Application by Sembcorp Utilities (UK) Limited for an Order Granting Development Consent for the Proposed Tees CCPP Project

The Examining Authority's Written Questions and Requests for Information (ExA WQs)

Issued on Wednesday 18 April 2018

Figure 7.3
Sensitive Human Receptors

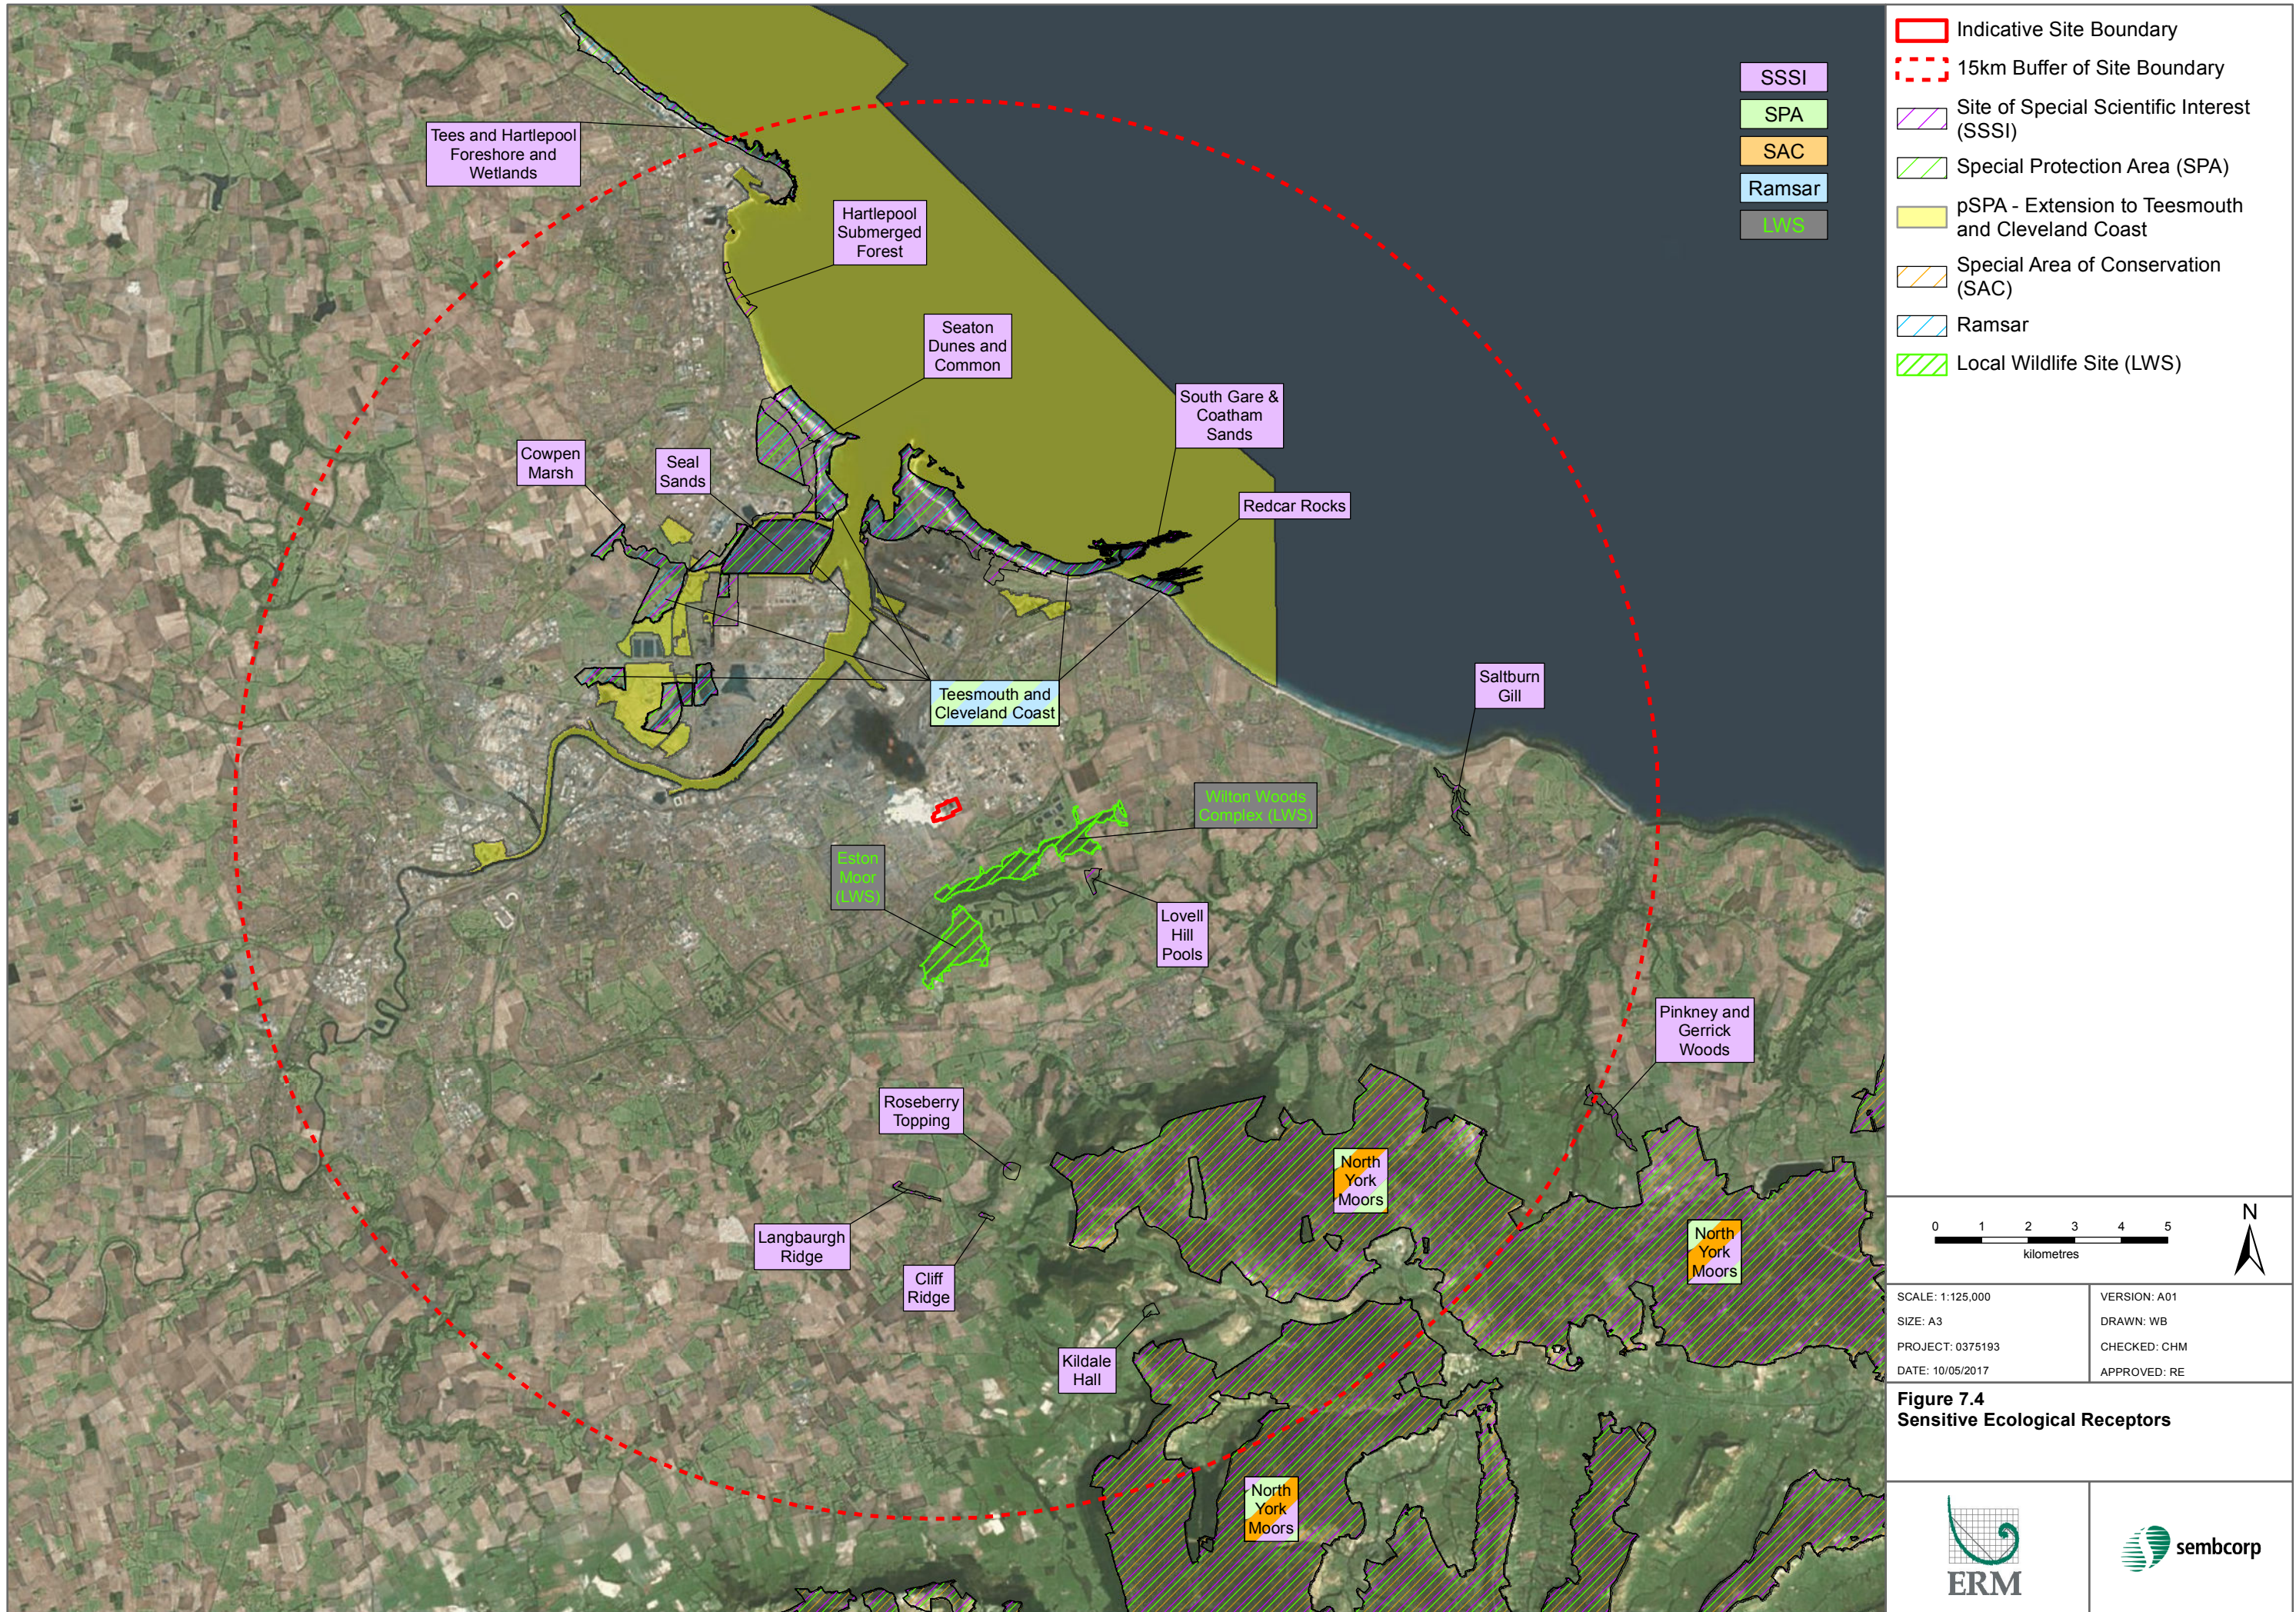
Q1.1.8	Redcar and Cleveland Borough Council Applicant	<p>In Table 7.1 of the ES [APP-049] Redcar and Cleveland Borough Council (RCBC) identified that Dormanstown air monitoring station had seen some 1 hour NOx '<i>spike</i>' concentrations.</p> <p>Why do you consider that this might have occurred and what effect would it have on nitrogen dioxide (NO₂)?</p> <p>RCBC indicated a spike of up to 200ug/m3 whilst the applicant indicated 93.7. Why is there such a difference?</p>
Q1.1.9	Applicant	Paragraph 7.82 of the ES [APP-049] states that the sensitive human receptors set out in Table 7.12

Ref No.	Respondent:	Question:
		are shown in Figure 7.3. In fact the receptors shown in Figure 7.3 are reflective of those presented in Table 7.14 rather than Table 7.12. Please clarify.
Q1.1.10	Applicant	Whilst acknowledging that the majority of land uses to the north of the application site, as described in paragraph 7.83 of the ES [APP-049] are industrial, why did the assessment not consider the nearest sensitive human receptors to the north / north west particularly when Figure 7.1 shows the prevailing wind direction to be mainly from the south west?
Q1.1.11	Applicant	With reference to paragraph 7.96 of the ES [APP-049], is it appropriate to use current baseline pollution concentrations to represent future baseline concentrations, particularly as paragraphs 7.103/7.104 indicate that NO ₂ levels are in a downward trend?
Q1.1.12	Redcar and Cleveland Borough Council Applicant	<p>In Table 7.14 of the ES [APP-049] the annual mean baseline NO₂ at Plantation Road and West Lane, Grangetown are significantly higher than at the other sensitive receptor locations.</p> <p>What are the reasons for this and the implications?</p>

Figure 7.6
99.8th Percentile 1 Hour NO₂, PC only, µg/m³

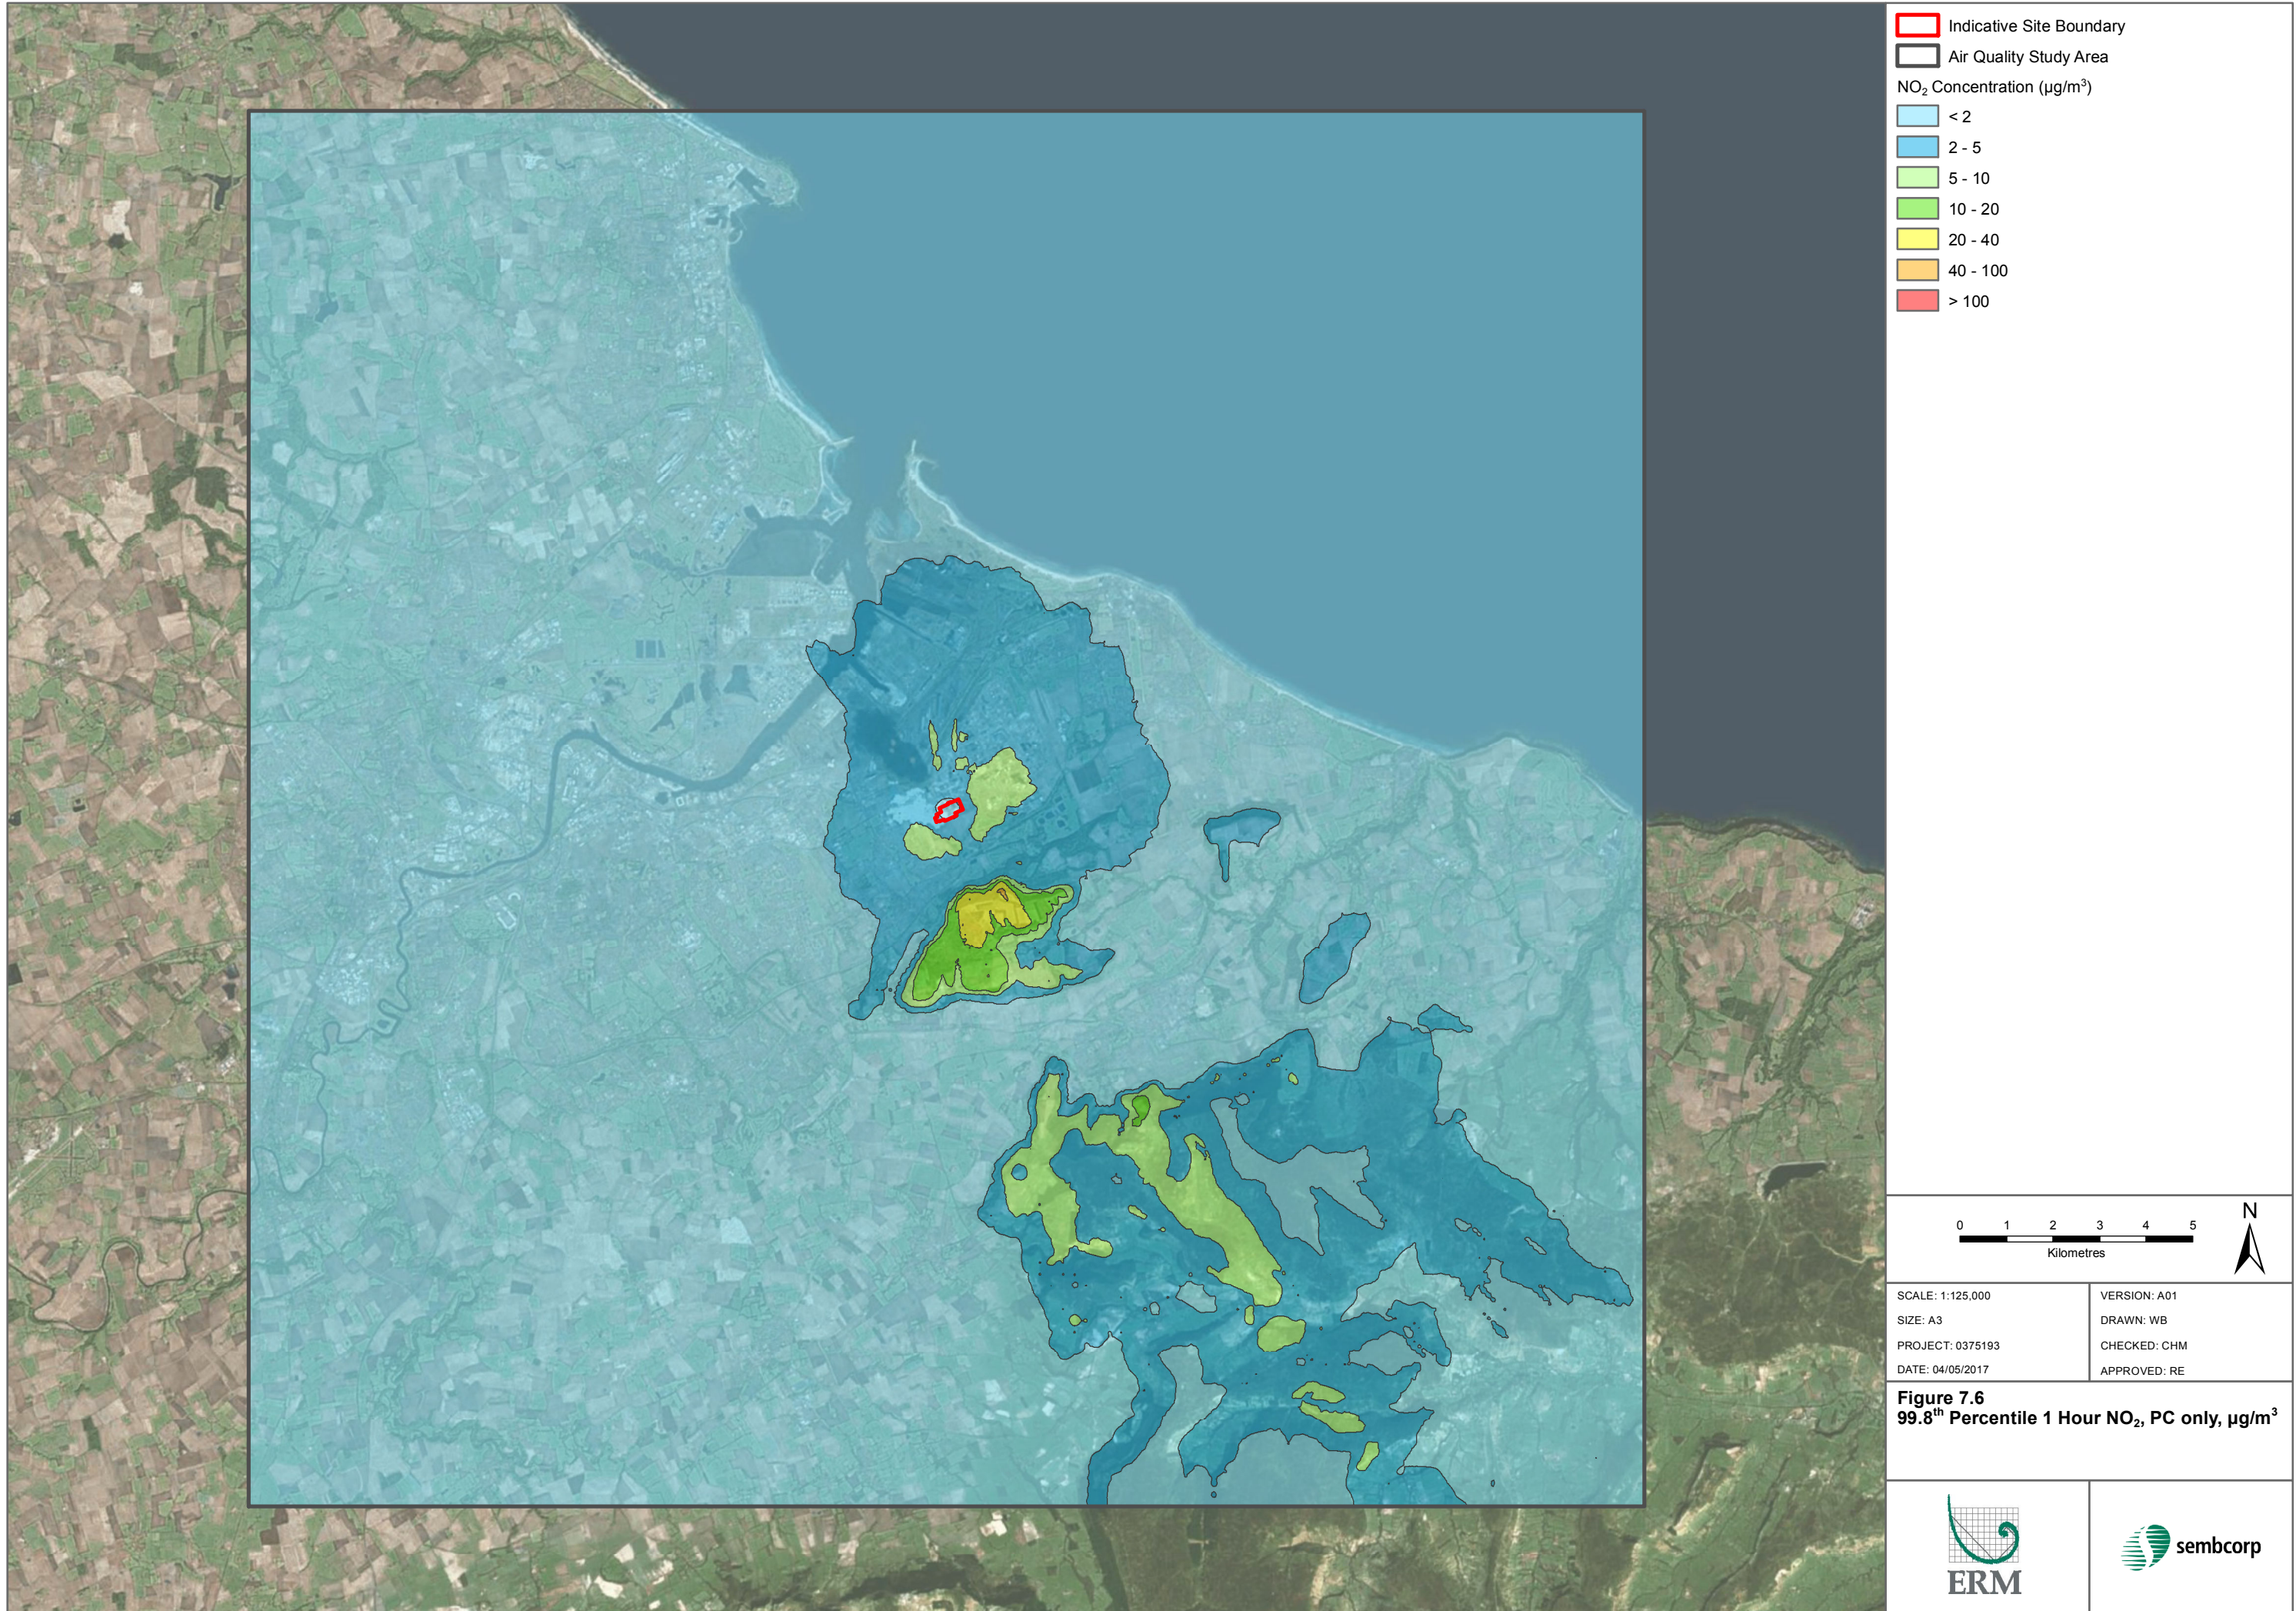
Q1.1.27	Applicant	<p>With reference to Table 7.14, and Figures 7.5 and 7.6 of the ES [APP-049], please confirm the location of the maximum off-site impact, as it appears to differ between short and longer term effects.</p> <p>Confirm, in each case, whether there are any 'human health' or sensitive ecological receptors at the point of maximum off-site impacts identified.</p>
2	Biodiversity, Ecology and Natural Environment	
Q1.2.1	Applicant Natural England	<p>Table 9.1 of the Environmental Statement (ES) [APP-051] refers to Natural England's (NE) letter to the Applicant (dated 26 April 2017) regarding the scope of surveys.</p> <p>Please provide a copy of the letter. In commenting on the letter, reference is made to 'off-site effects on the Teesmouth and Cleveland Coast Special Protection Area (SPA) and Ramsar site' [ES Table 9.1].</p>
